**Addendum No. 1**

RE: Contract # C204684

**Haywood County (B-3186, B-5898)**

BRIDGES #155 AND 158 OVER RICHLAND CREEK ON US-23/74 AND  
BRIDGE #168 OVER US-19 AND US-23 ON US-23/74.

FINAL PAVEMENT MARKING SCHEDULE

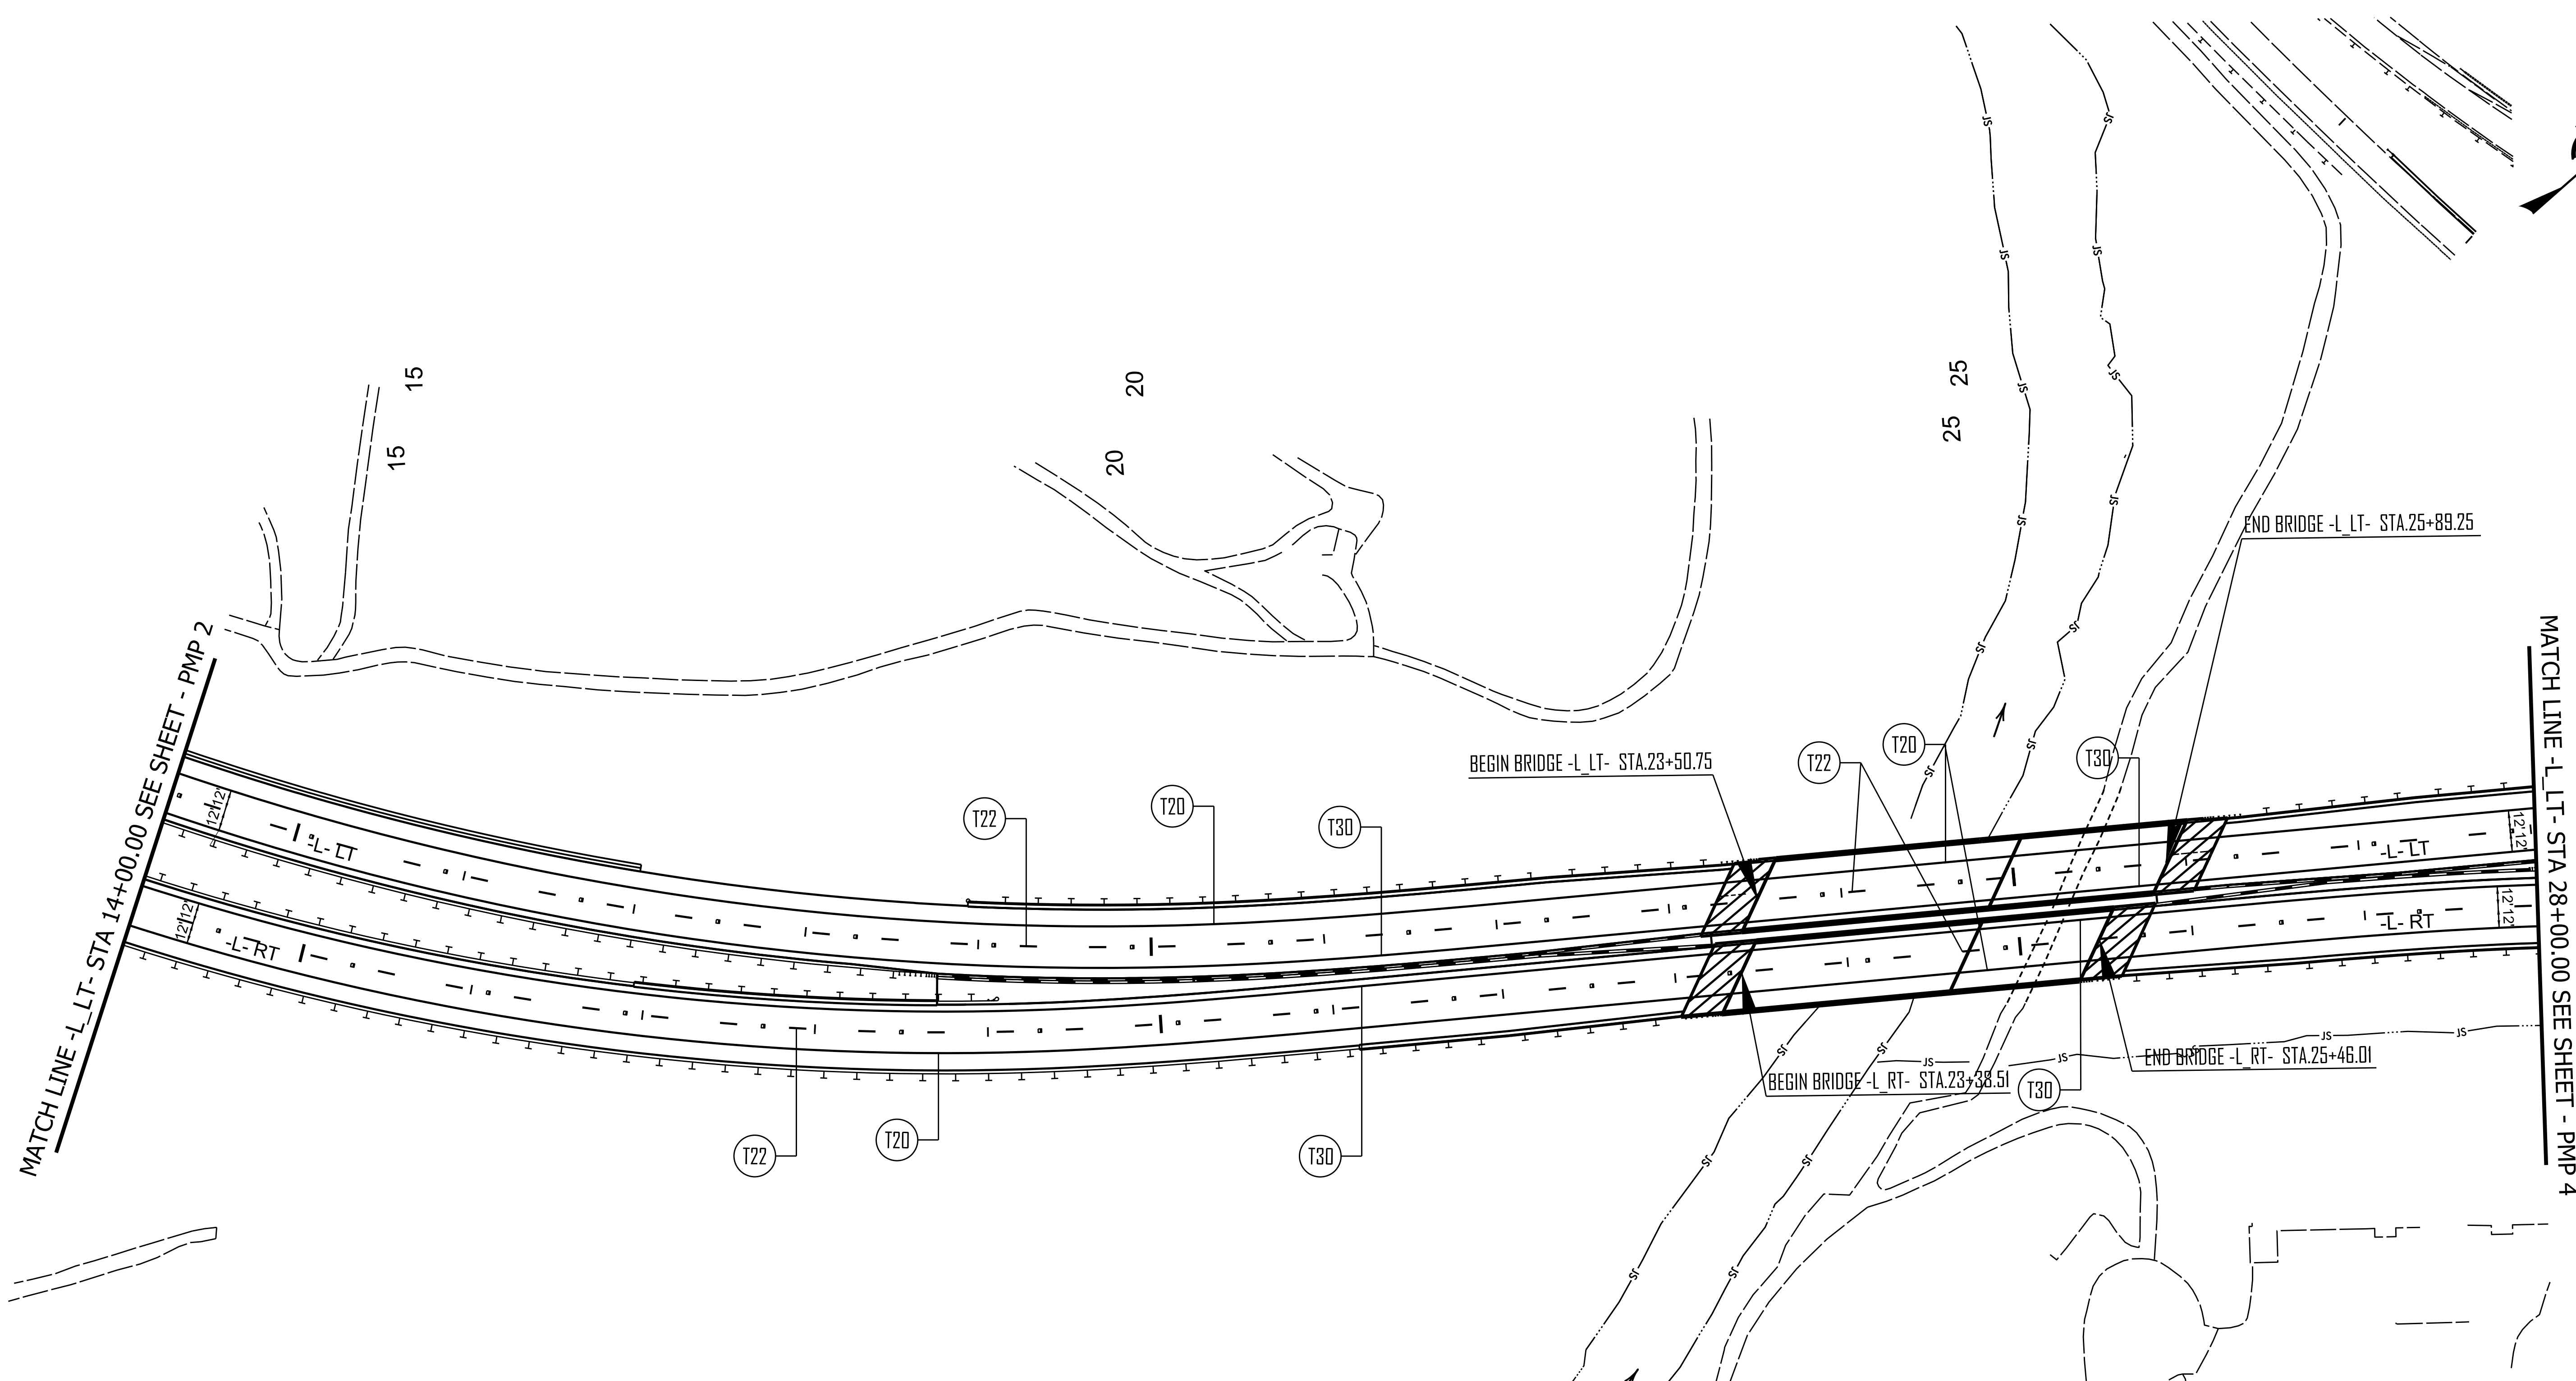
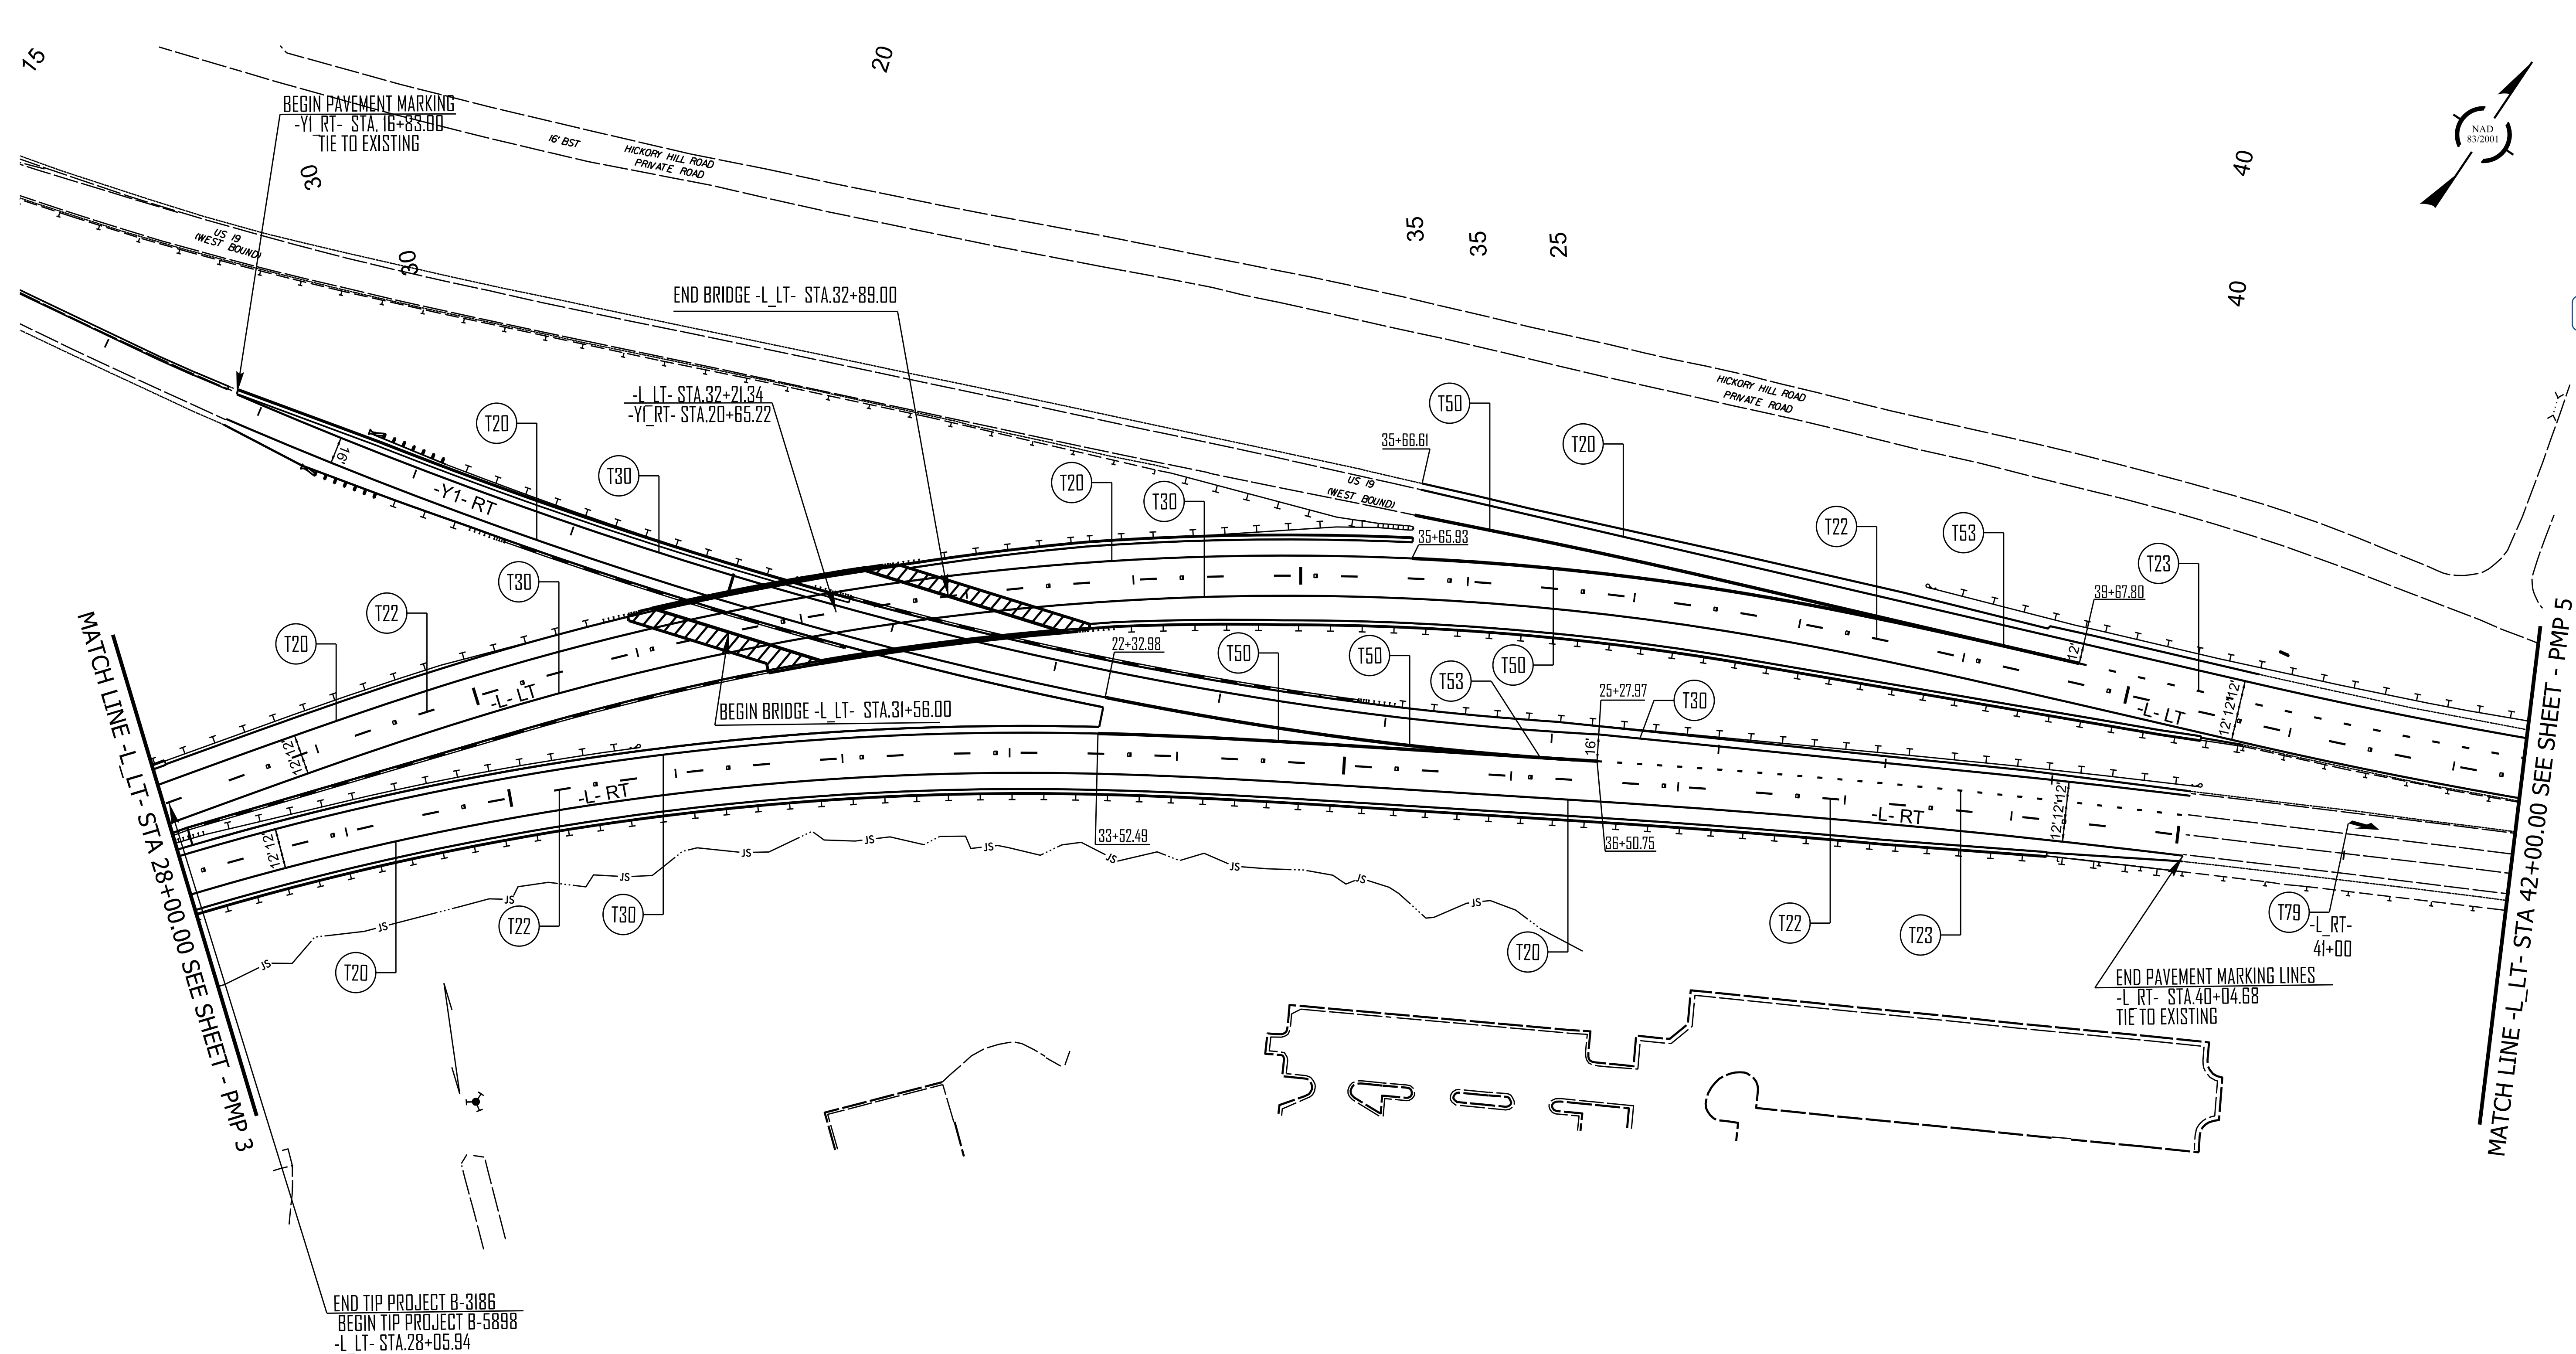
Sheet No.	Revision
PMP-1 thru PMP-5	Final Pavement Marking Schedule revised.
PMP-4 thru PMP-5	Merge arrows added, gore area striping revised.
